London Luton Airport Expansion

8.76 Applicant's response to Written Questions - Historic Environment

Application Document Ref: TR020001/APP/8.76

**8.76 APPLICANT'S RESPONSE TO WRITTEN QUESTIONS –
HISTORIC ENVIRONMENT**

Drawing Title: **Figure 10.2 Location of Designated Cultural Heritage Assets (Plan 2 of 2)**

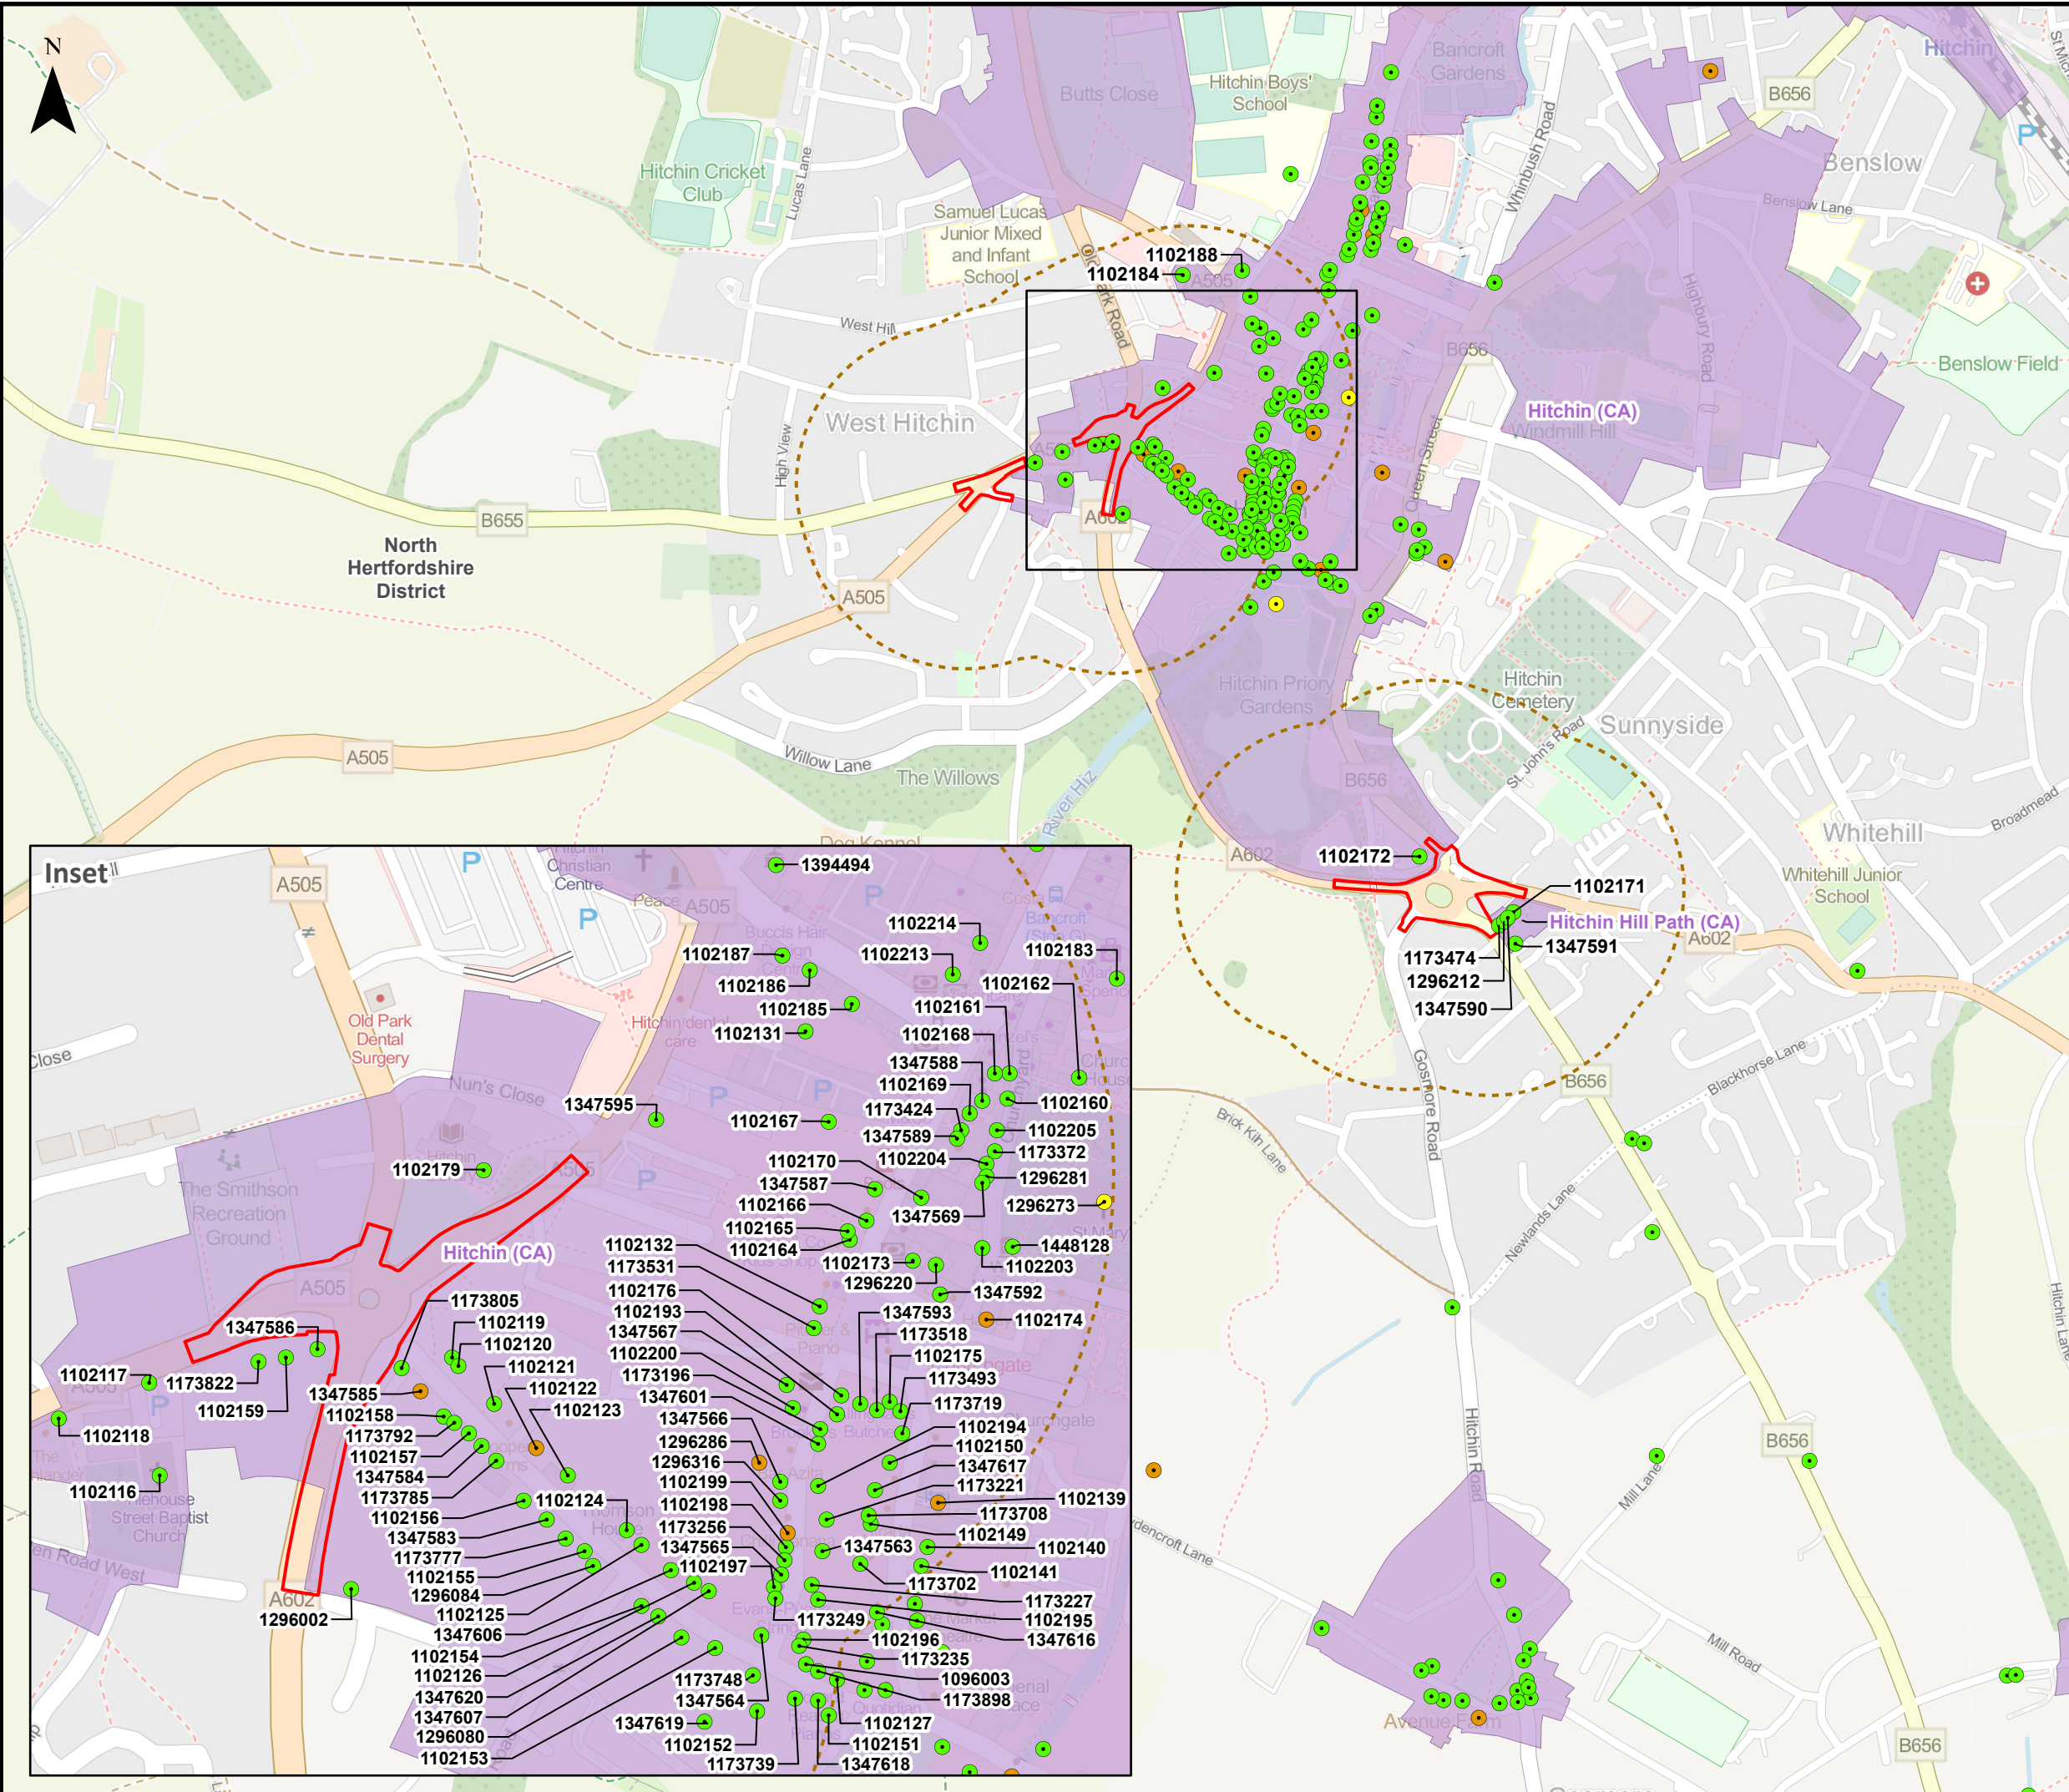
PED.1.10	<p>Question: Designated Assets</p> <p>RR-0698 states that Appendix 10.2 - Cultural Heritage Gazetteer [APP-073] fails to list Historic England entry 1102442.</p> <p>Please confirm whether this asset has been omitted. If so, it is requested that the Cultural Heritage Gazetteer [APP-073] and Figure 10.2 in the Cultural Heritage Figures [APP-150] is updated along with any assessment of effects in the ES.</p> <p>Response:</p> <p>Keepers Cottage is a grade II listed building. Its omission was due to a technical error within the Historic England dataset and Historic England has notified its Digital Team to this error. The Appendix 10.2: Cultural Heritage Gazetteer [TR020001/APP/5.02] has been updated so it now includes this asset, along with a summary impact assessment. There would be no change to the asset's setting that would impact its heritage significance, and there would also be no harm to its heritage significance. The updated gazetteer has been submitted at Deadline 4.</p>

Drawing Title
Figure 10.7 Designated Heritage Assets Change in 2039 Do-Something - Do-Minimum Daytime LAeq,16h Air Noise Contours

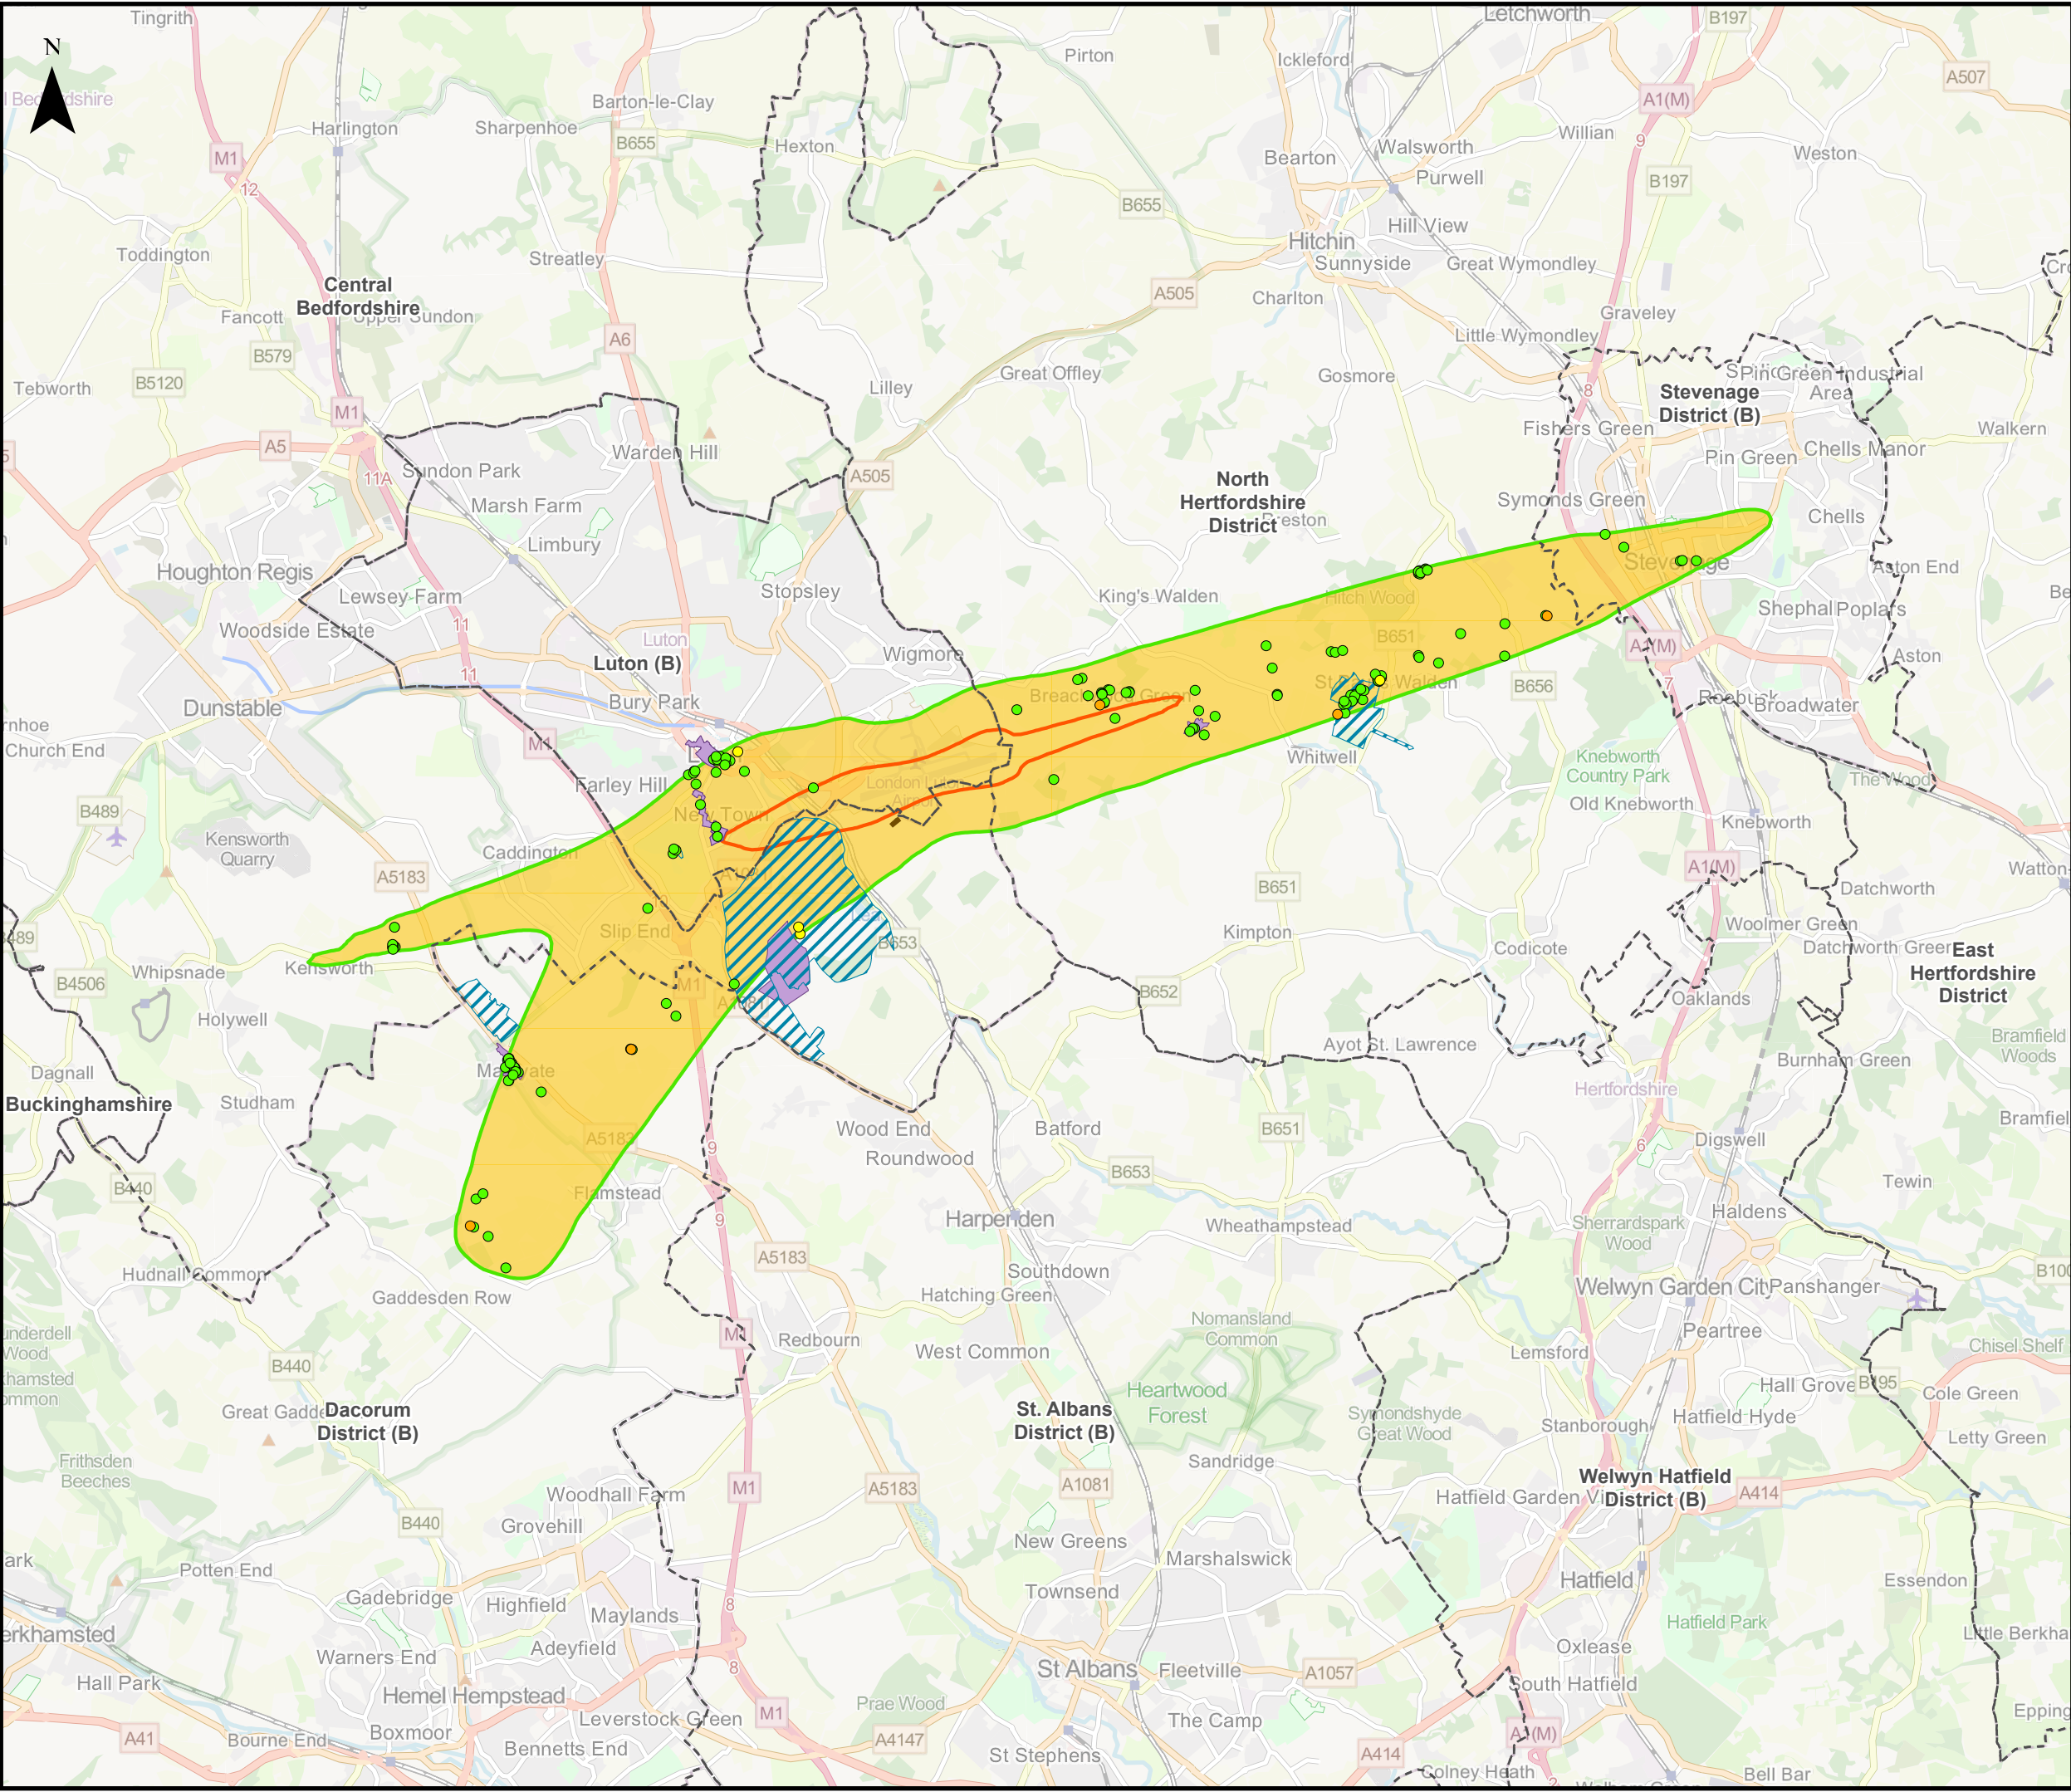
PED.1.12	<p>Question: Impact Assessment for St. Paul's Walden Bury Grade I listed Registered Park and Garden (RPG)</p> <p>Chapter 10 of the ES [AS-077, paragraph 10.9.88] states that the noise change contours for assessment Phase 2a and assessment Phase 2b operation [APP-150, Figures 10.7 and Figure 10.8] show an increase from the future baseline of between 1dB and 1.9dB above 51dBLAeq,16h but below 63dBLAeq,16h where this would be a negligible change to the park's noise environment. Looking at Figure 10.8, at Phase 2b it appears that parts of the park would represent a change of between 2dB and 2.99dB.</p> <p>Please confirm if this is correct and if so, provide any updates to the assessment in Chapter 10 of the ES.</p> <p>Response: Chapter 10 of the ES [AS-077, paragraph 10.9.88] states that the noise change contours for assessment Phase 2a and assessment Phase 2b operation would increase from the future baseline between 1dB and 1.9dB resulting in a negligible change to the park's noise environment. This reflects the situation across the majority of the asset The Applicant acknowledges that the change in predicted noise levels does vary within the St Paul's Walden Bury Registered Park and Garden with some areas experiencing a change of between 2dB and 2.99dB during Phase 2b [APP-150, Figure 10.8].</p> <p>The change in noise identified during Phase 2b will affect the southern section of the park. As noted in Chapter 10 of the ES [AS-077] paragraph 10.9.86, the baseline noise environment changes in the southern part of the park where the farm buildings are part of a working farm. Aviation noise from overhead aircraft approaching the airport is part of the asset's noise environment but the noise does not intrude to such an extent as to detract from the asset's rural character.</p> <p>The noise increase during assessment Phase 2b would arise from the increased frequency of flights. The noise environment within the park is not a quiet experience and does not rely solely on quietness for an appreciation of its heritage interests. The noise change contours for assessment Phase 2a and assessment Phase 2b operation (Figure 10.7 and Figure 10.8 of the ES [APP-150]) show an increase from the future baseline of between 2dB and 2.99dB above 51dBLAeq,16h but below 63dBLAeq,16h. This would be a negligible change to the park's noise environment and would not affect its setting or impact its heritage value. This is therefore assessed as no impact and no effect. Despite the increase in noise levels, the effect on the asset remains the same as reported in Chapter 10 of the ES [AS-077].</p>
